CUMNOR PARISH COUNCIL

BOTLEY WEST SOLAR FARM (BWSF) REF: EN010147

Cumnor Parish Council - Comments for Deadline 7 on submissions received at Deadline 6

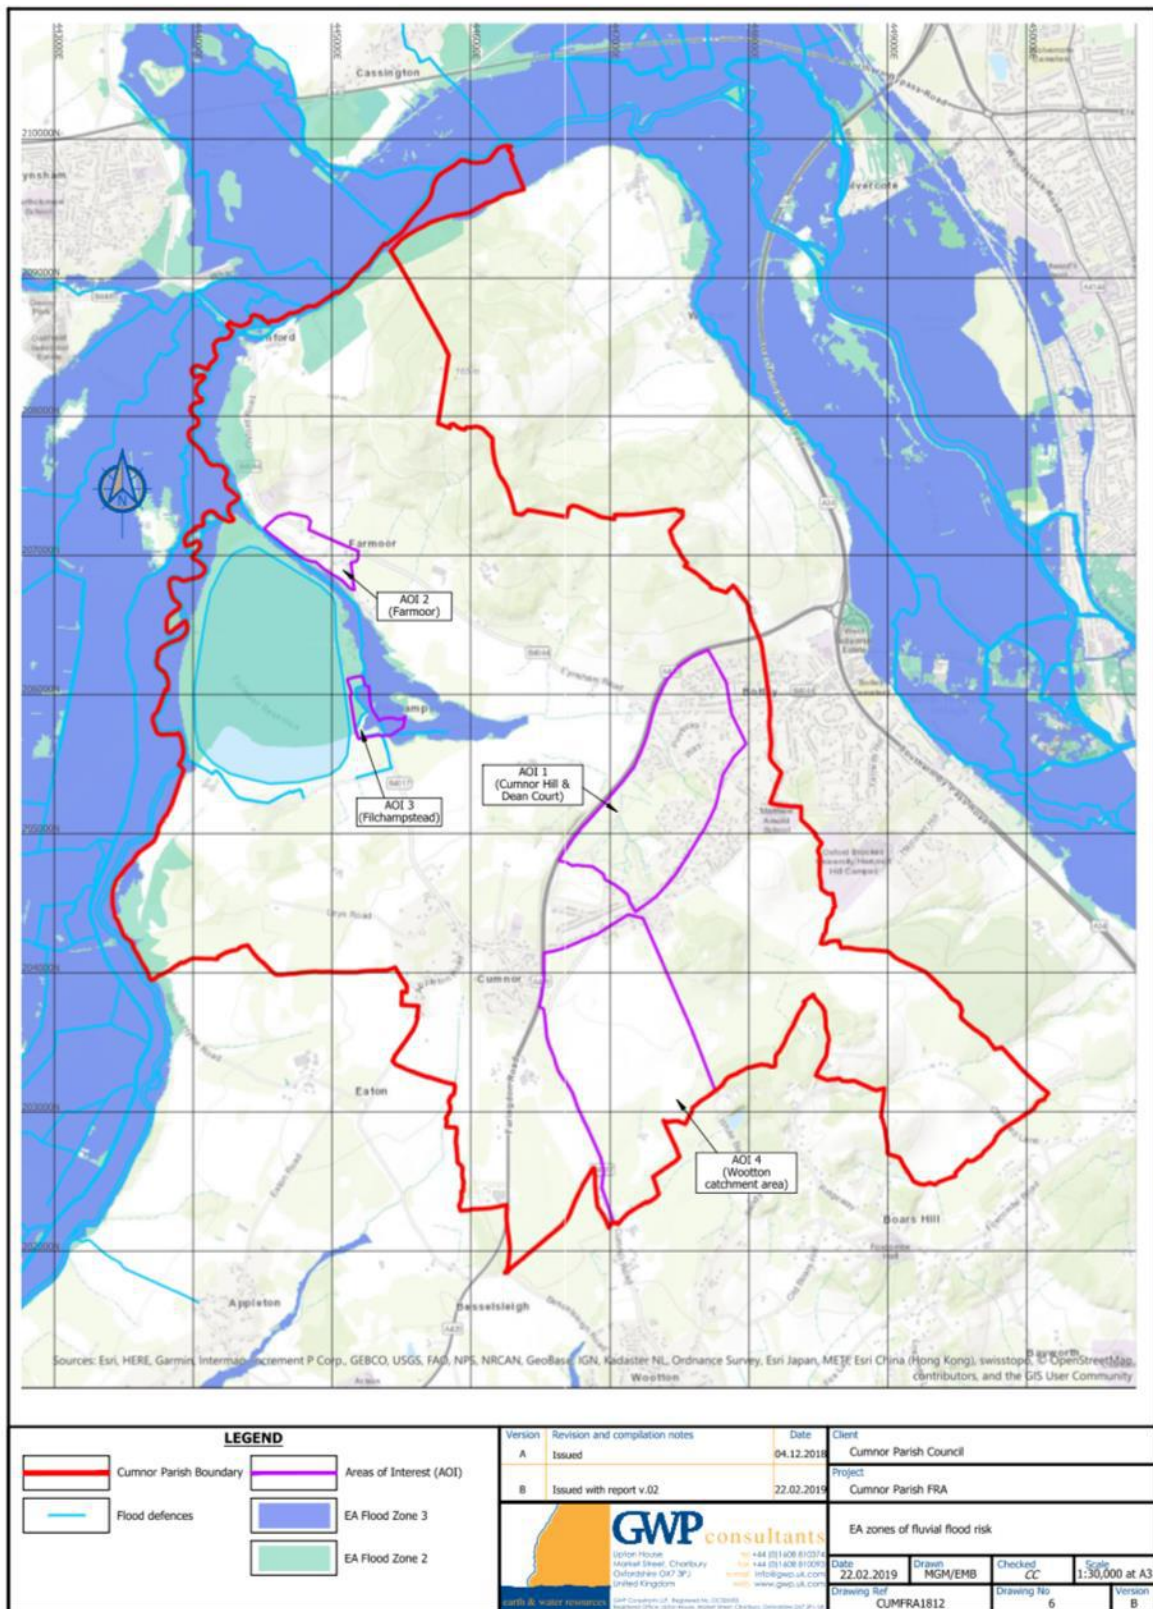
5.3.4. While Table 1.8 on page 20 of the applicant’s **REP3-020** does selectively quote CNP Policy RNE2, it does not include the policy interpretation paragraphs (para 111-114 in **REP1-057**) that detail what is required for flood risk assessments to be policy compliant. Given their omission and any other evidence to the

contrary it is concluded that a RNE2 flood risk policy assessment has not been carried out.

5.4. **So, as the Examination process draws to a conclusion and some 5 months after first raising the issue in the Examination process, and three years after raising it in prior ‘consultations’, the applicant has still not addressed CNP Policy RNE2 by actively undertaking the assessment requirements of that policy.**

5.5. **The application therefore remains non-compliant with CNP (REP1-057) policy RNE2.**

51 - Lower Whitley Rd, Filchampstead

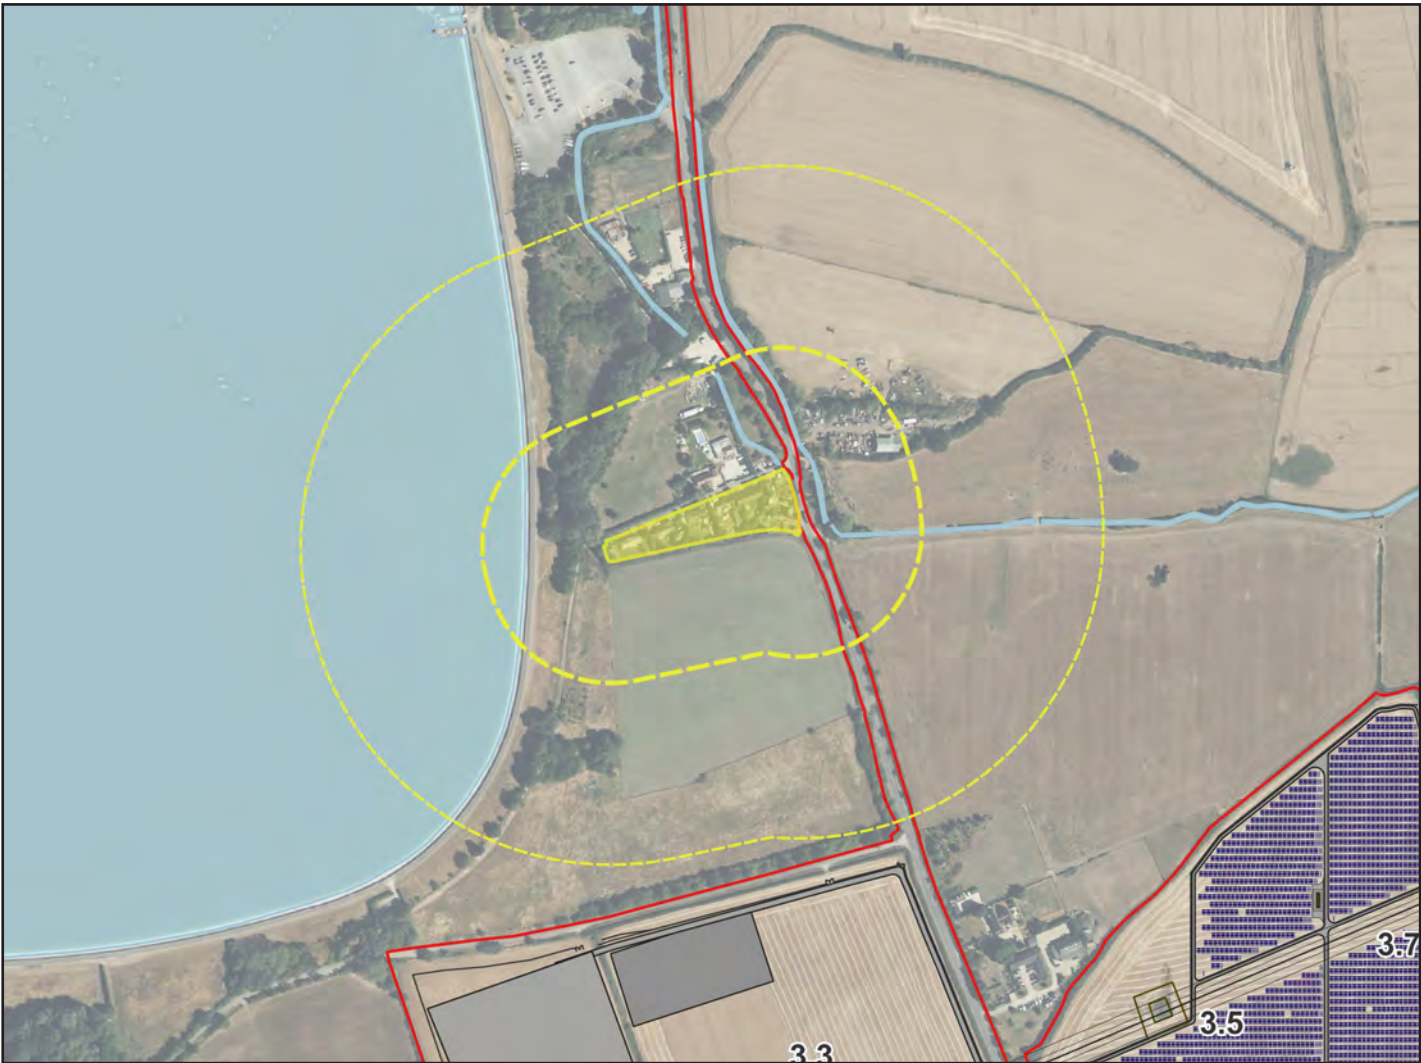
8.6. Omission of Filchampstead – a hamlet within the settlement hierarchy in Cumnor Parish

There is no reference to Filchampstead in the text of **REP6-064** and so no assessment of RVAA impacts for either the construction or operation phases.

Regarding operation, CPC observes that the RVAA Figure 1.62 in **REP6-064** merely describes residences on Lower Whitley Road (junction with B4017 at w3w ///unroll.beads.trades) as '*other residential property*'

Given that all the 8 properties on the south side of Lower Whitley Road contain dwellings and gardens that face south towards Tumbledown, and that, for example, the 17th century Tumbledown Cottage (see list of Local Heritage Assets on page 76 of **REP1-057**) lies only 257m from the applicant's Field 3.3 (see page 52 of **REP6-118**) CPC concludes this is incontrovertible evidence of the scale of errors and omissions in the RVAA, which claims a '1km study area' (para 1.3.4 in **REP6-064**)

52 - Denman’s Farm

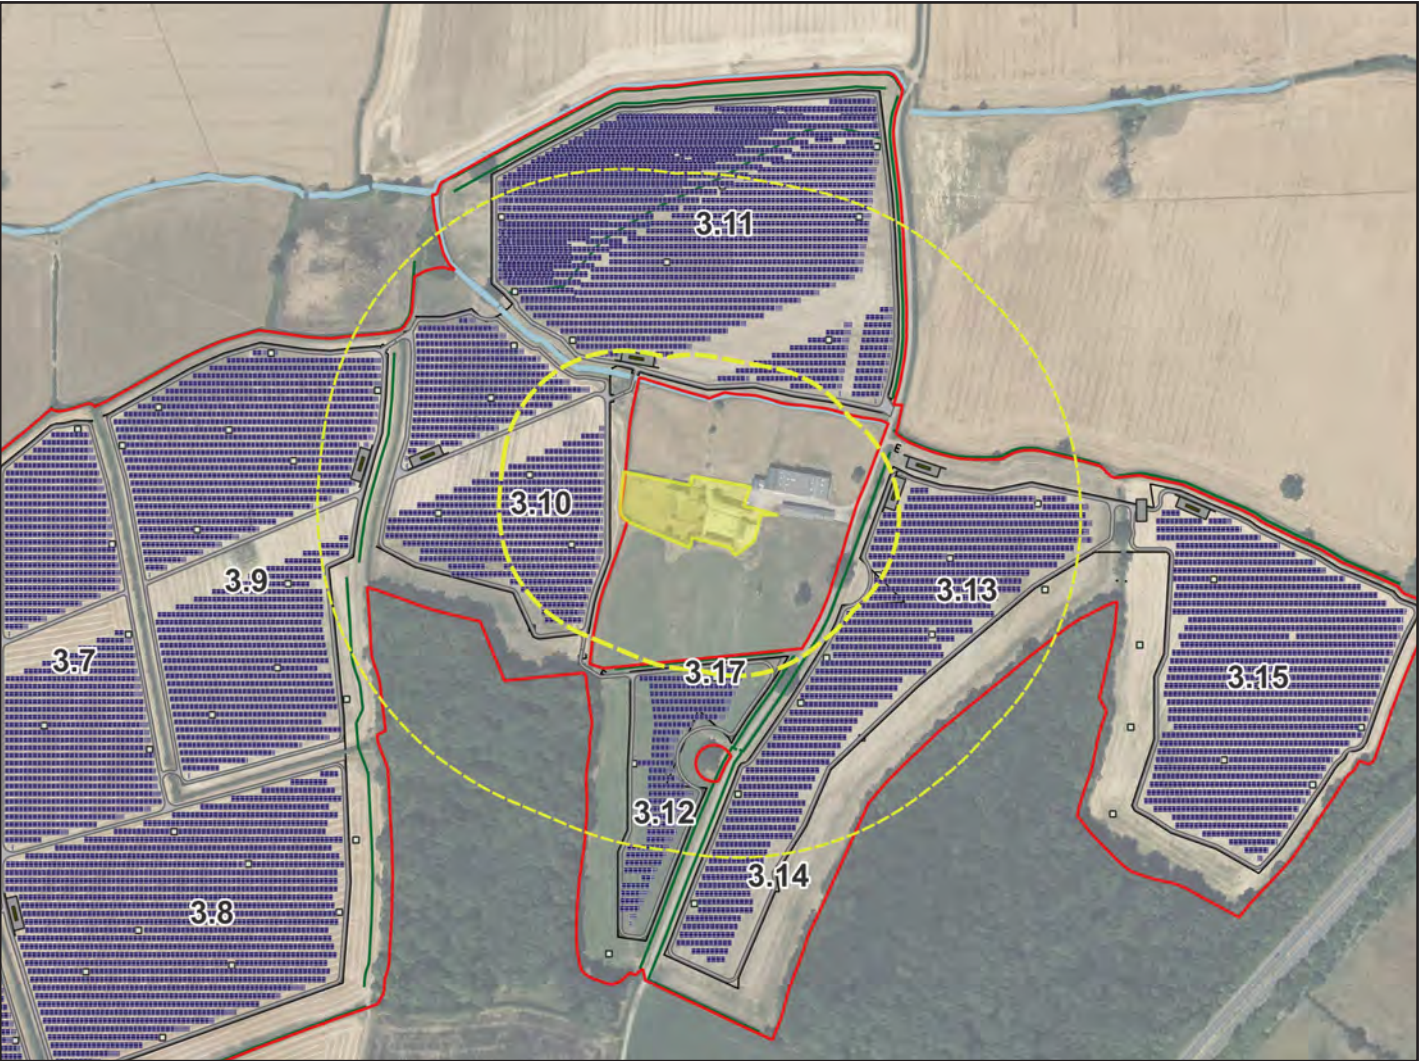
8.9. Errors in applicant's assessment of Jumpers Farm, Denman's Farm, Lake View and Heidersbach.
